**CITY OF ALBUQUERQUE  
PLANNING DEPARTMENT  
November 14, 2012  
DRB Comments**

**PROJECT # 1009506**

**RE: Tracts 14-18, 20 & 21, Volcano Cliffs Unit 6**

SKETCH PLAT FOR
MONTECITO WEST
BEING A REPLAT OF
TRACTS 14-18, 20-21,
VOLCANO CLIFFS UNIT 6
AND A PORTION OF
ALBERICOQUE PLACE NW,
RETABALO ROAD NW &
VILLA REAL ROAD NW

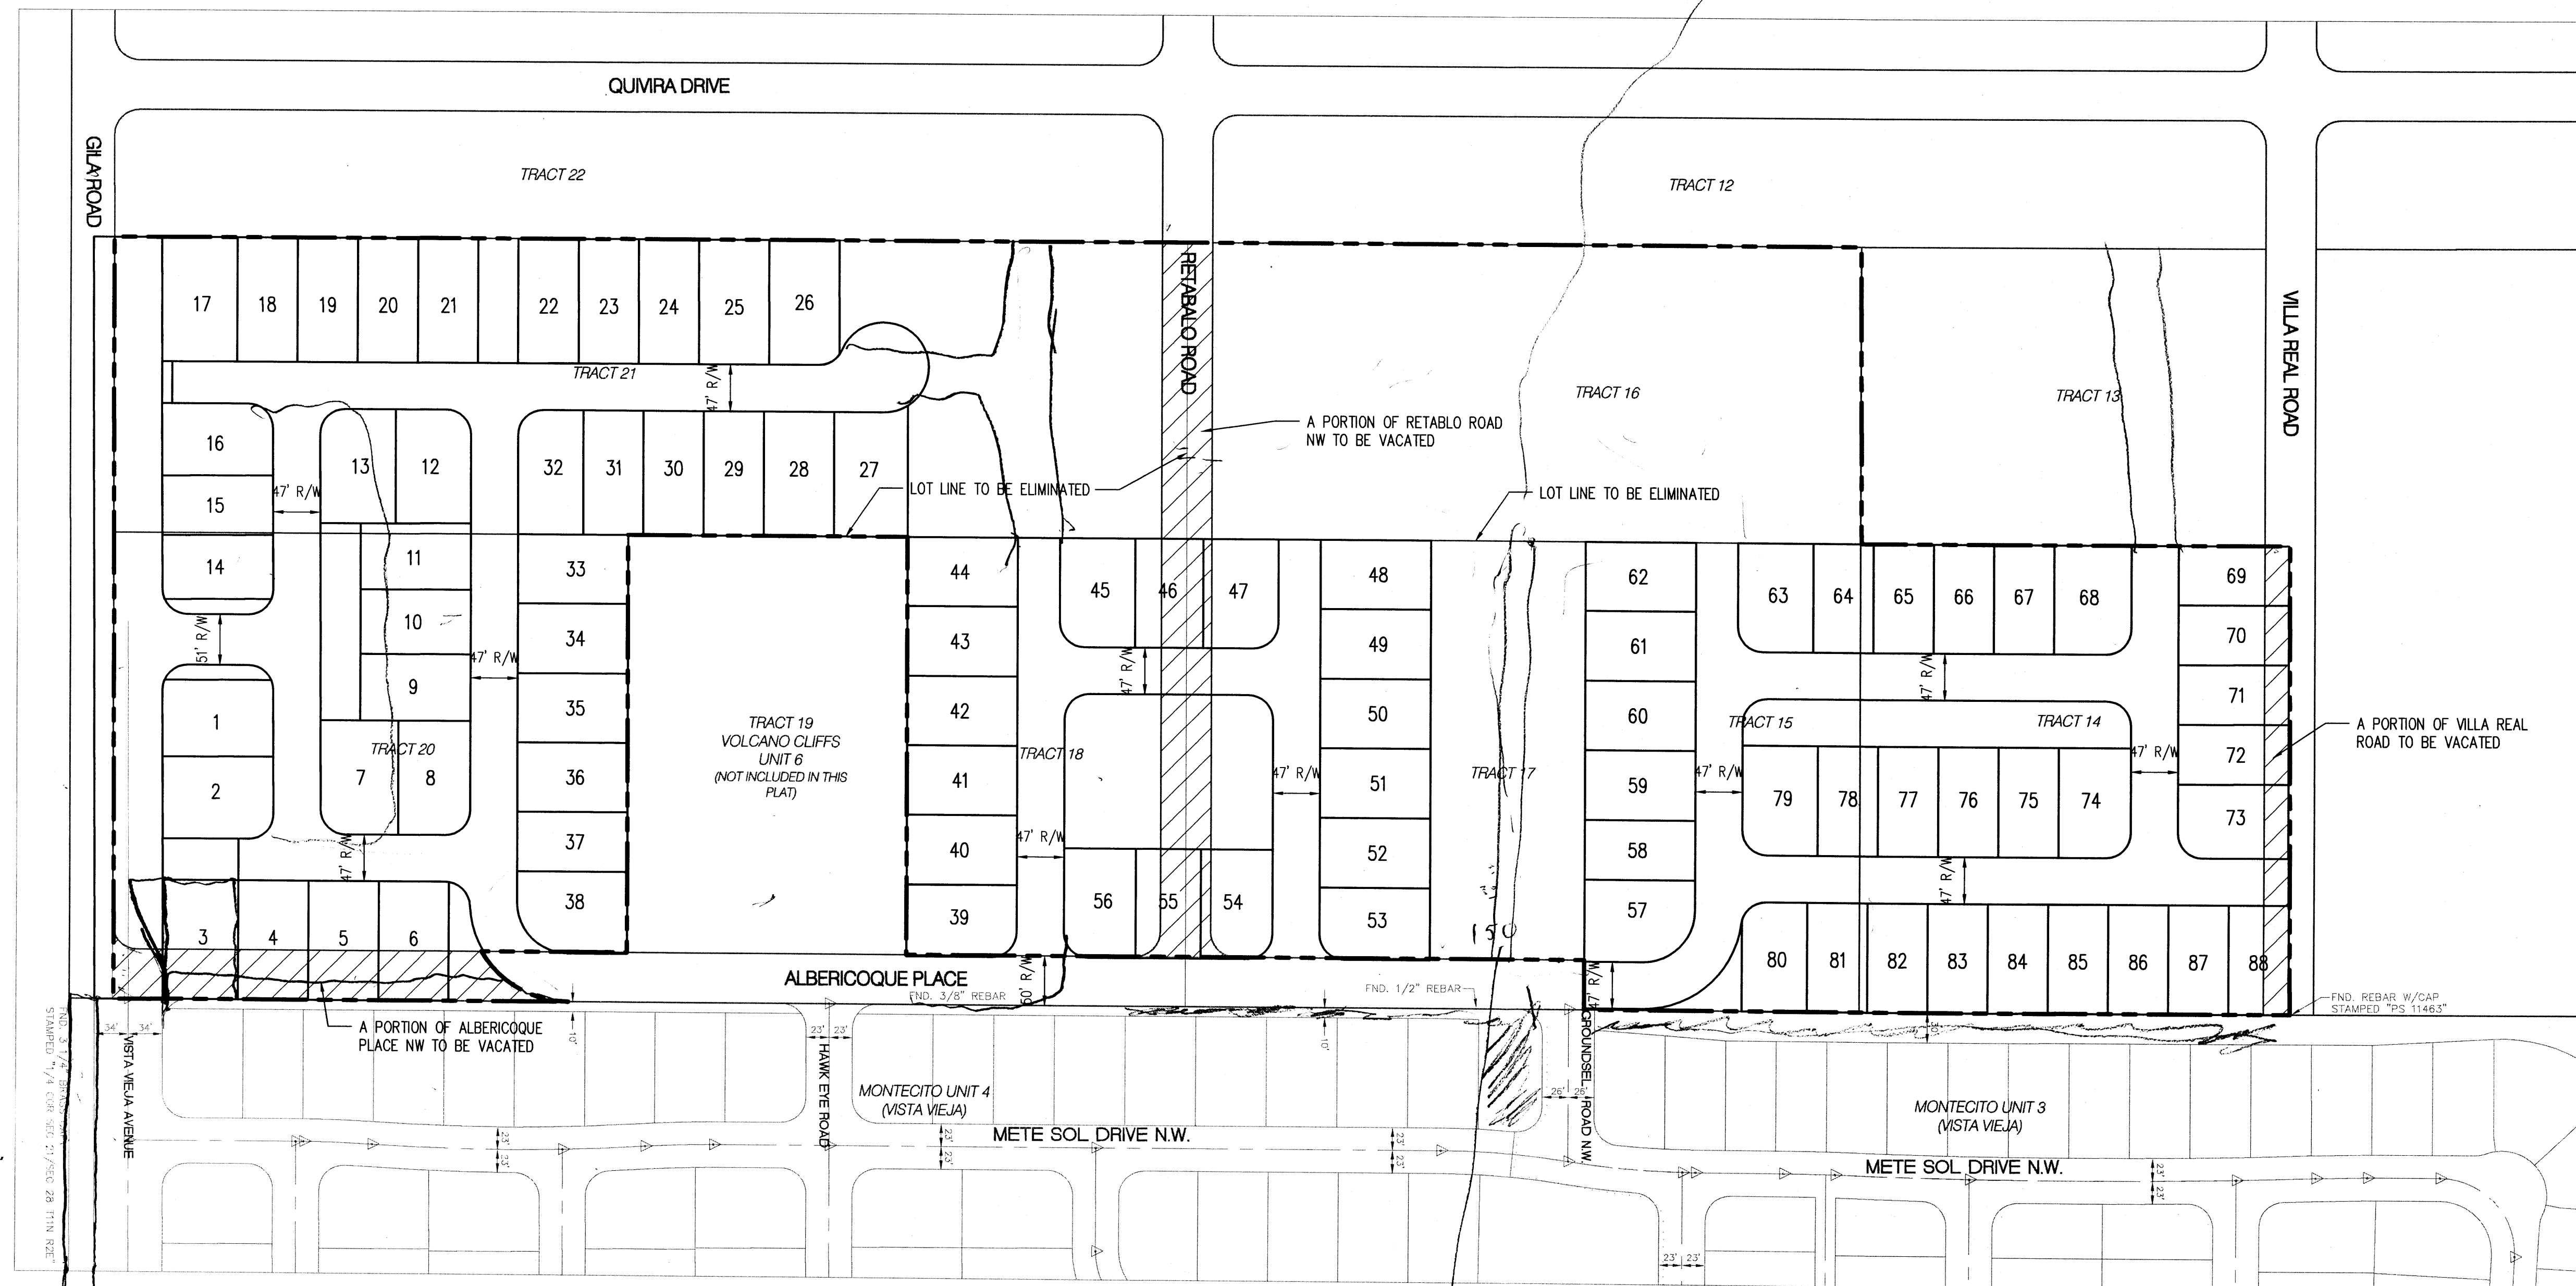
Refer to Section 14-16-3-16 of the Zoning Code for requirements of a Private Commons Development. Refer to Section 14-14-7-2 of the Subdivision Ordinance for requirements to Vacate Right of Way and its disposition. A vacation cannot leave unusable or substandard right of way (Villa Real NW).

Alternative lot layouts need to be explored – it is not suitable to create so many single loaded streets, and double frontage lots are extremely inefficient. Connectivity needs to be provided within the subdivision and from east to west.
